**WELWYN HATFIELD BOROUGH COUNCIL
EXECUTIVE DIRECTOR - PLANNING, PUBLIC PROTECTION AND GOVERNANCE**

DELEGATED APPLICATION

Application No: 6/2021/3216/HOUSE
Location: 9 Vicarage Close Northaw Potters Bar EN6 4NY
Proposal: a roughly rectangular Erection of a single storey rear extension, a two storey side extension, and alterations to driveway and fence
Officer: Ms Elizabeth Mugova

6/2021/3216/HOUSE

DRAWING NO. **C5519VIC/21/IOS**

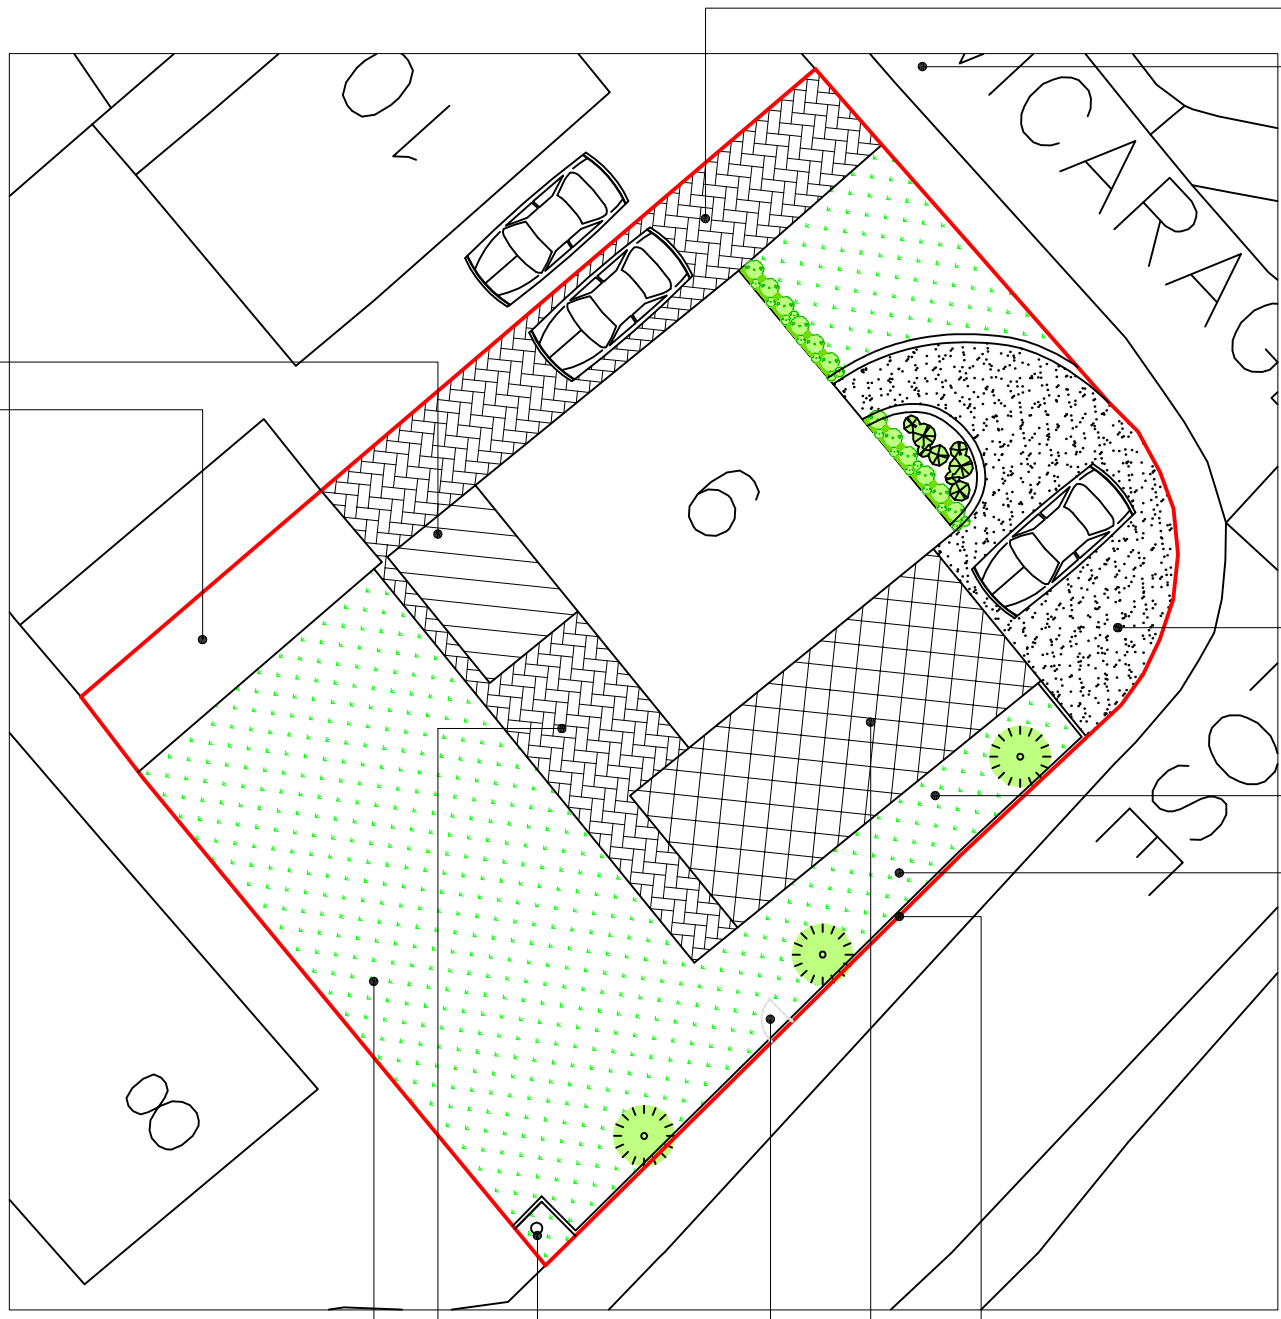
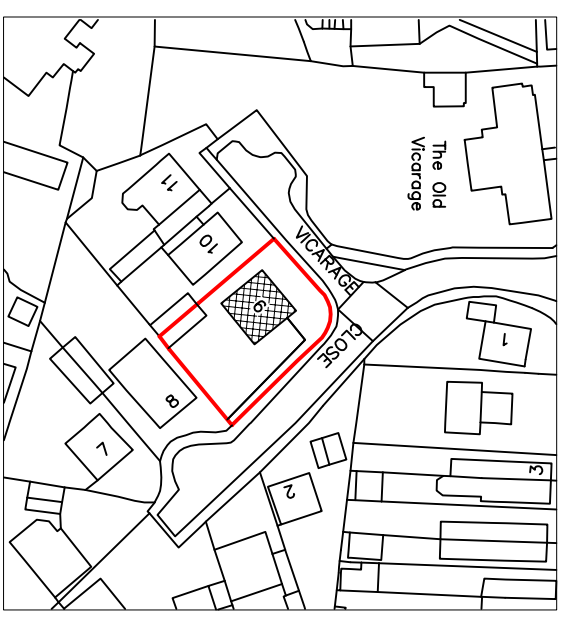
According to drawing No. C55/9VIC/21/OS, the existing fence would be moved to the boundary line, as a result, the telecoms pole on the southern corner of the application site would be located within the fenced area. However, it has been confirmed that the piece of land where the telecoms pole is situated is within the land owned by the applicant.

PROPOSED REAR ELEVATION  
Scale 1:100

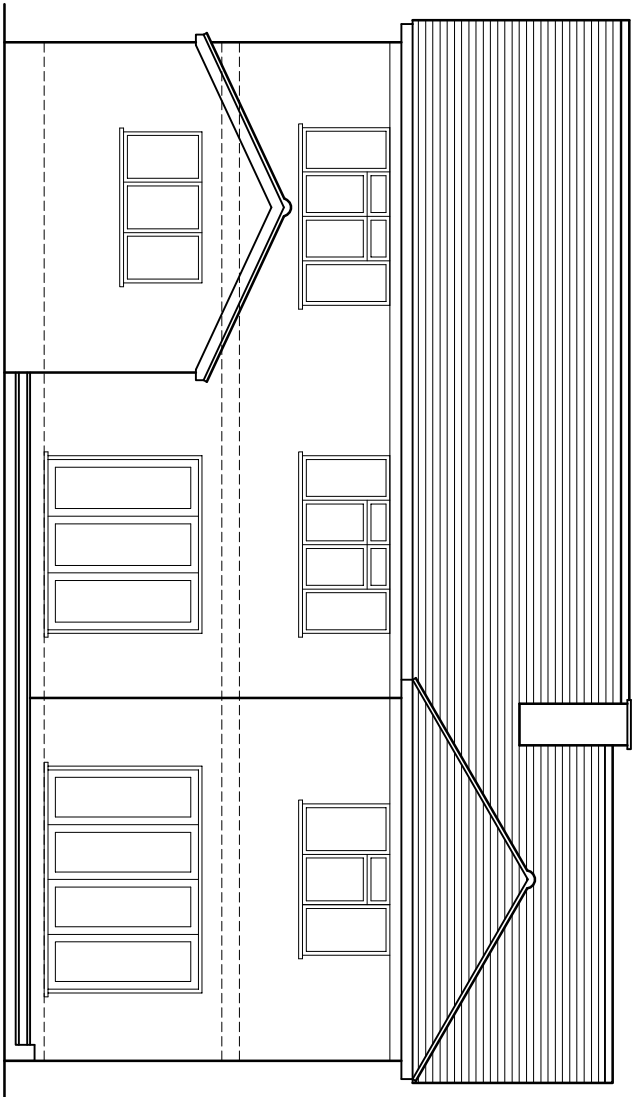
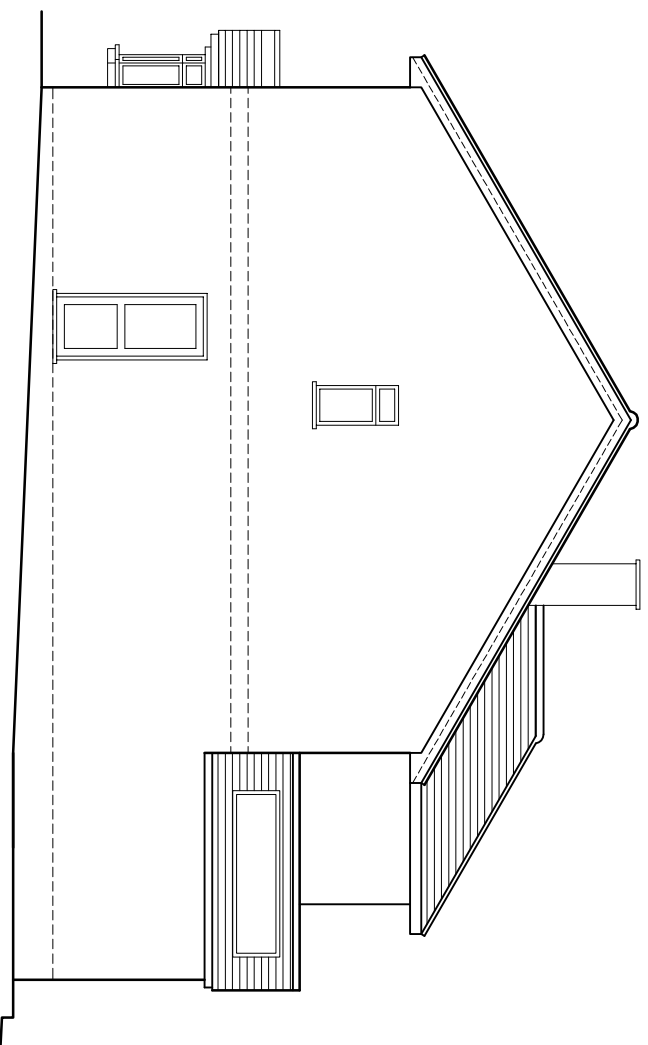
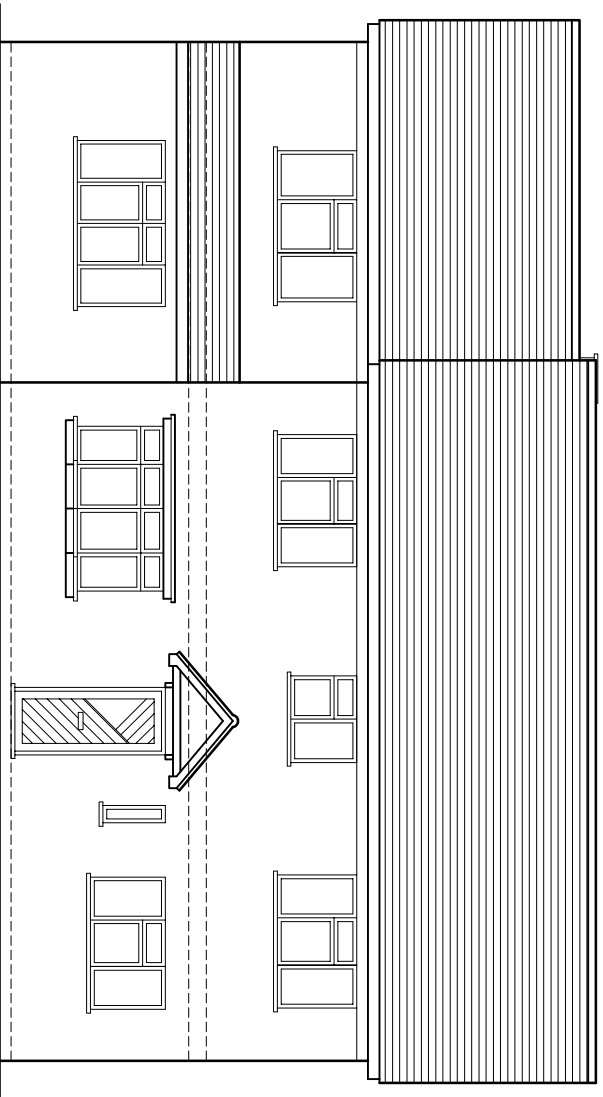
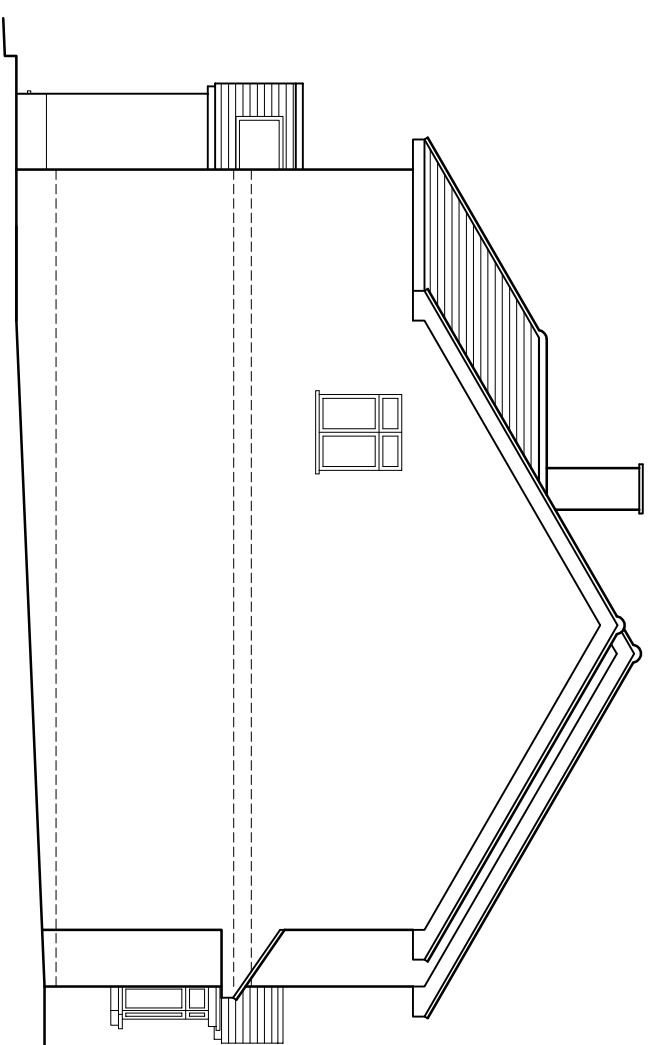
In visual terms, whilst the proposal would add bulk to the side of the dwelling, the addition would be unobtrusive and in keeping with the scale of the host dwelling. The proposed two-storey side extension would be set back by approximately 750mm from the existing front elevation. In addition, the first floor extension would have a pitched roof, similar to the host dwelling with a ridge that is set down below the level of the existing roof ridge. On the other hand the single storey rear extension would measure approximately 3 metres in depth and 4 metres in width and would be concealed from view of the street scene. Furthermore, the proposed roof of the rear extension would match the existing roof thus reflecting the character and form of the host dwelling.

On the other hand, the first floor side extension protrudes by approximately 2 metres to the rear of

the host dwelling and the rear facing bathroom window to the proposed principal bedroom would be facing No. 8. It's been noted that No. 8 is set back from the street, therefore, in terms of privacy, views from the bathroom window would predominantly be to the front garden/driveway of this neighbouring property. In addition, the bathroom window is likely to be glazed with obscure glass. As such, it is considered that the proposal would not have any adverse impact on No. 8.
